# CITY OF ALBUQUERQUE

Re: Certification Submittal for Final Building Certificate of Occupancy for  
Paiz Wilmore 4-PLex, [L-15 / D057]  
1909 Wilmore Drive SE  
Architect's Stamp Dated 02/27/09

**Re: 1909 Wilmoore Dr S.E., Grading and Drainage Plan  
Engineer's Stamp dated 5-5-08 (L15/D057)**

**Re: Four Plex @ 1909 Wilmoore Dr. SE—Lot 3, 1909 Wilmoore Drive SE,  
Traffic Circulation Layout  
Architect's Stamp dated 5-29-08 (L-15/D057)**

PAIZ WILMOORE
4-PLEX TRAFFIC CIRCULATION LAYOUT
1909 WILMOORE DRIVE SE
ALBUQUERQUE, NM

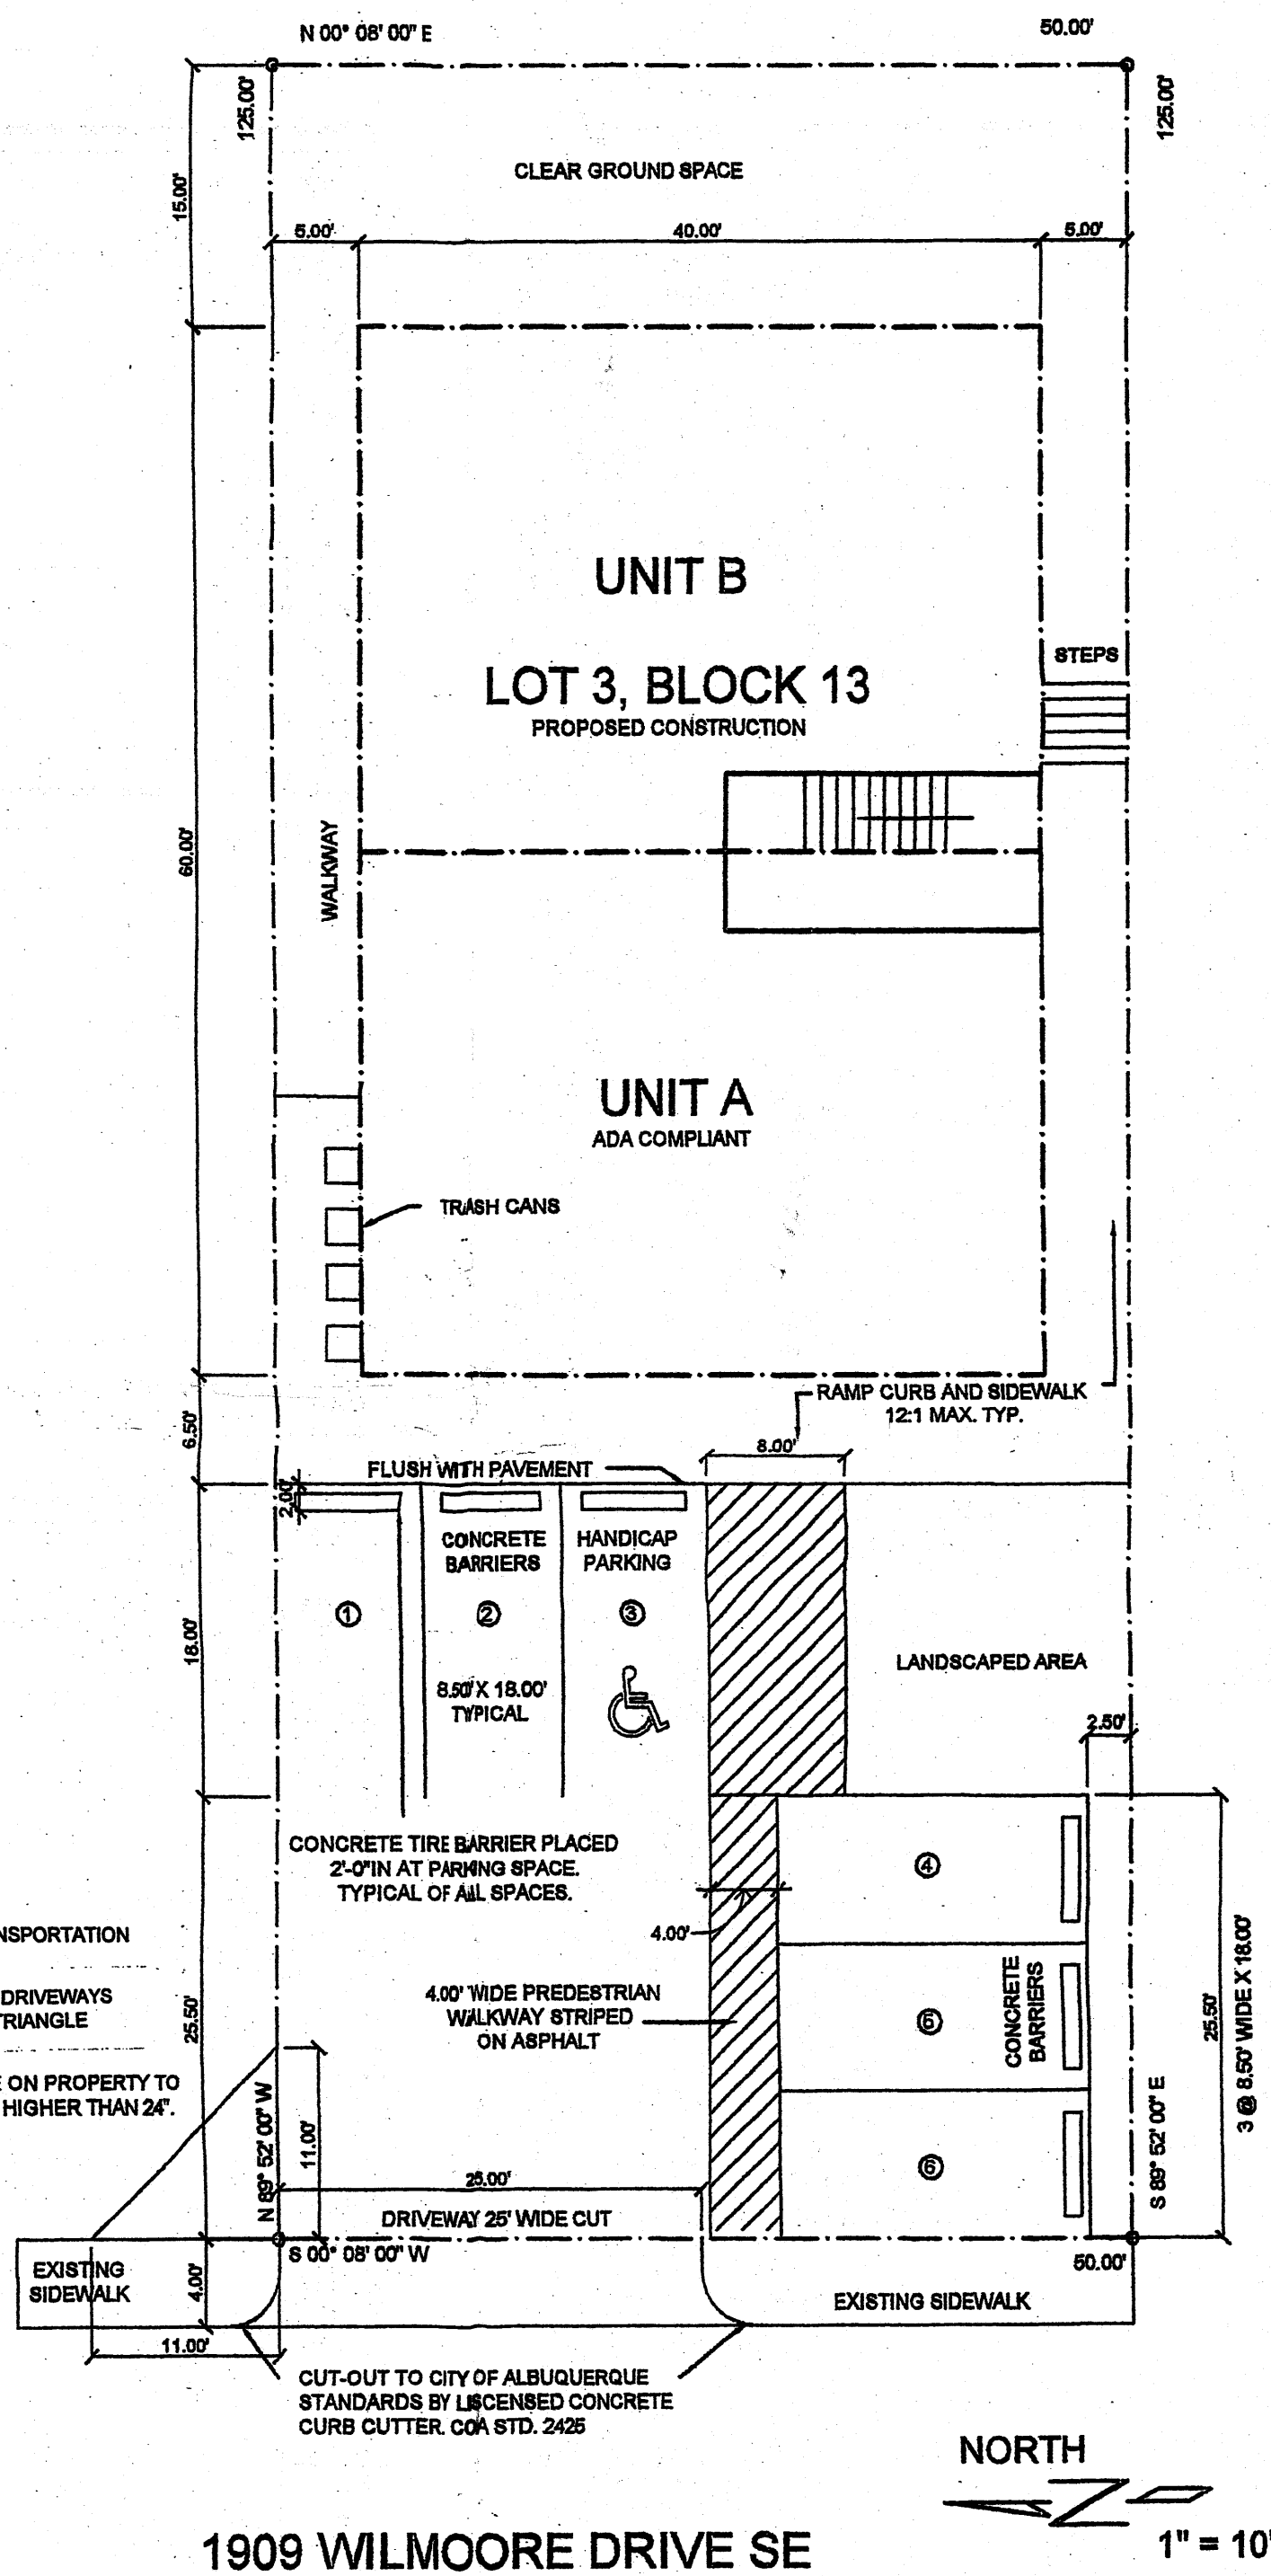
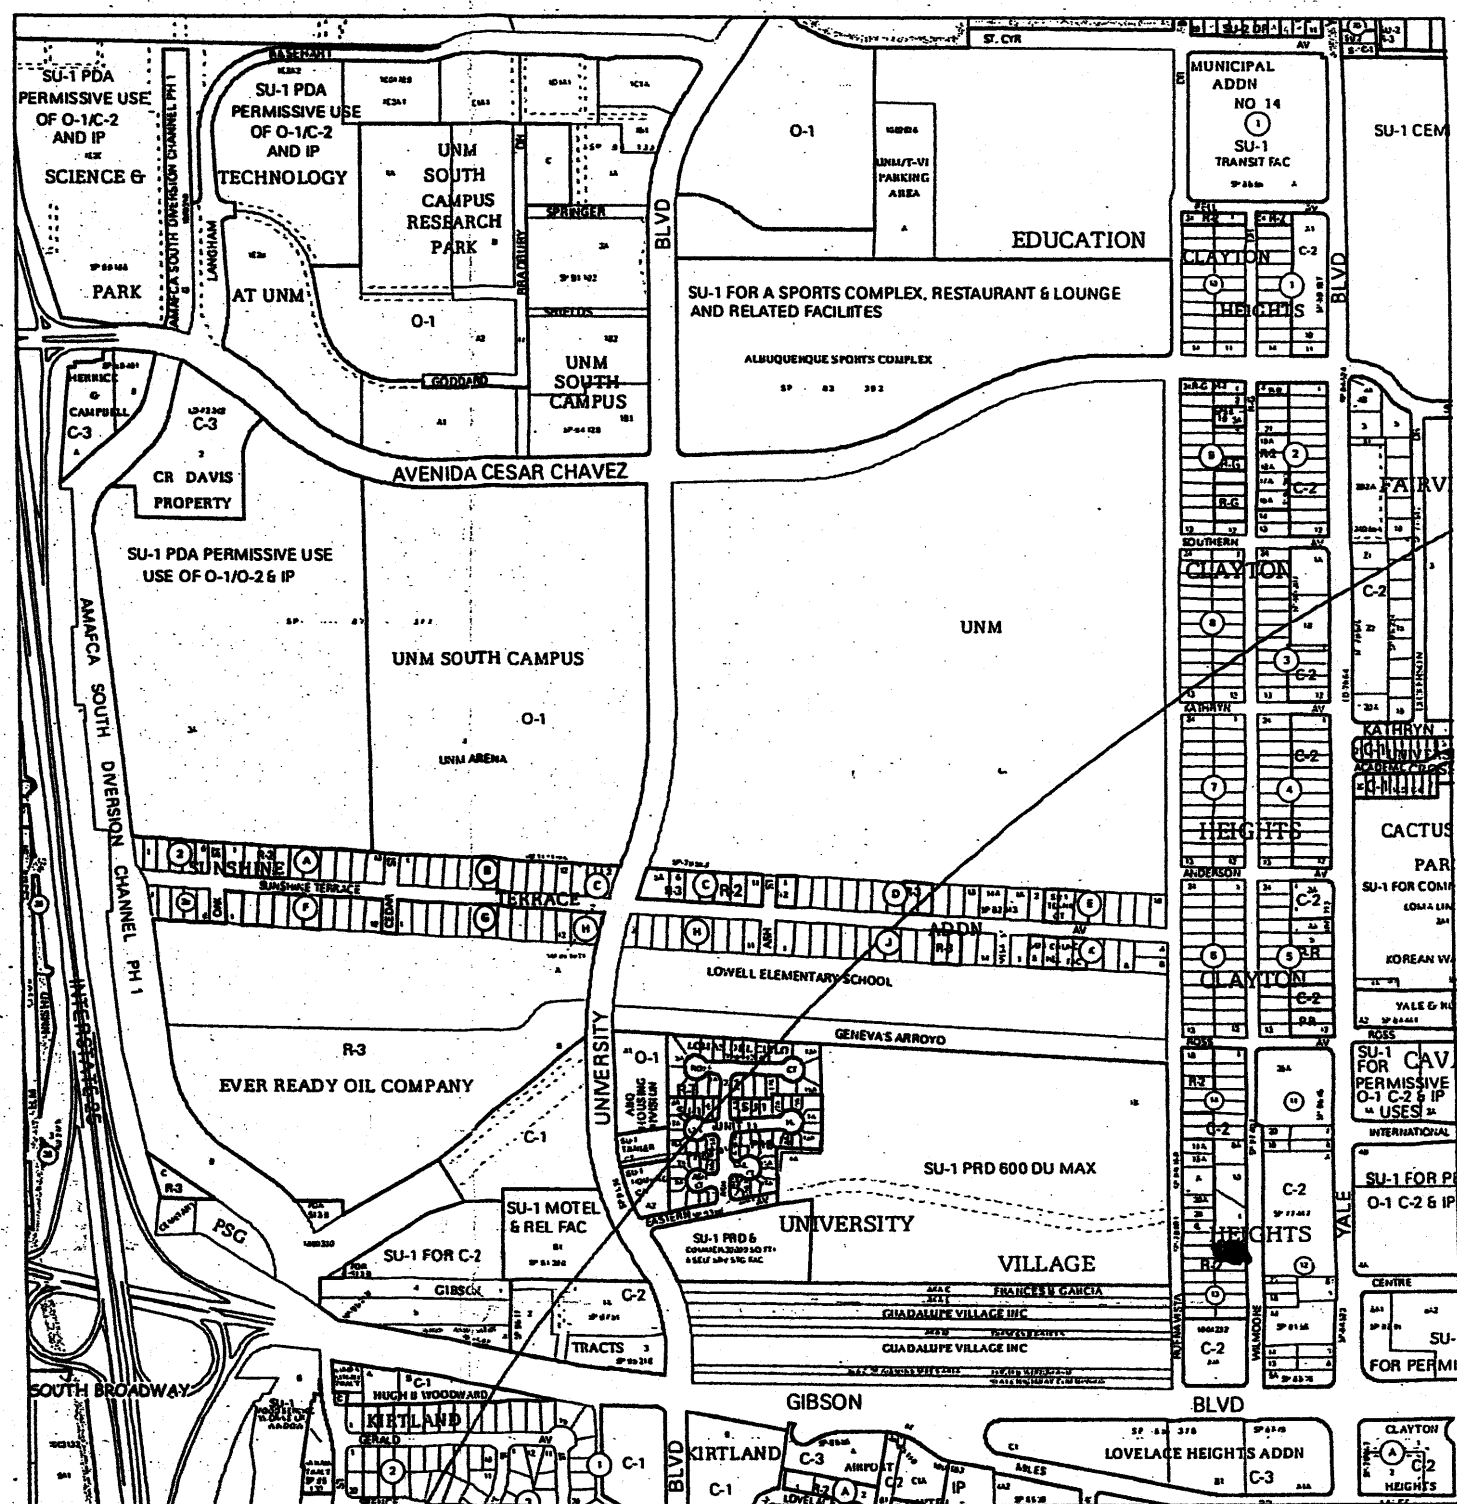
Based upon the information provided in your submittal received 6-04-08, the above referenced plan cannot be approved for Building Permit until the following comments are addressed:

1. Provide a TCL plan with an original Architect's stamp, date, and signature.
2. Indicate on the vicinity map where the subject property is located.
3. Call out the width of all sidewalk, both existing and proposed.
4. Show the location of the nearest drive pad on the adjacent lots. — no drive pads, lots vacant
5. Residential drivepads must be located at least 5.5 feet from the property line (3' transition + 2-1/2' separation to the property line). See the *Development Process Manual*, Chapter 23, Section 6.A.
6. Per the *Development Process Manual*, Chapter 27, Section 2, Part B.1, only the following scales may be used:
  - 1" = 50'
  - 1" = 40'
  - 1" = 20'
  - 1" = 10'
  - 1" = 100' (for overall layouts only)

GRADING & DRAINAGE PLAN
1909 WILMOORE DRIVE S.E.
ALBUQUERQUE, NEW MEXICO
APRIL 2008

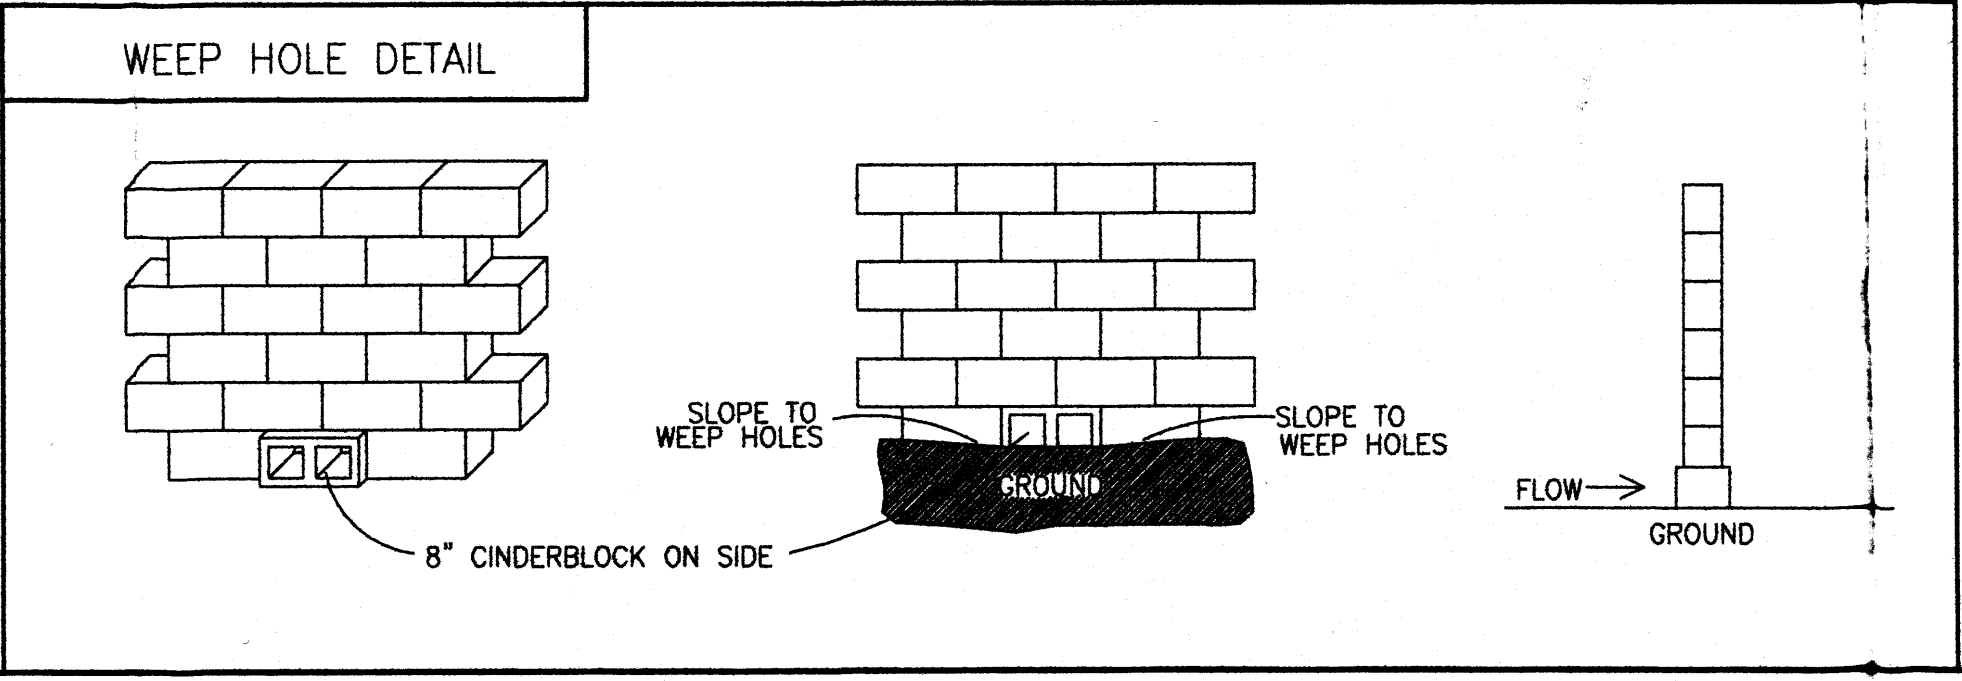
Based upon the information provided in your submittal received 5-6-08, the above referenced plan cannot be approved for Building Permit until the following comment is addressed:

- Note B should specify the type and size of the conveyance for runoff through the solid masonry walls. "Weep holes" could be interpreted as just leaving the joints open on the bottom course of block, which would be inadequate.
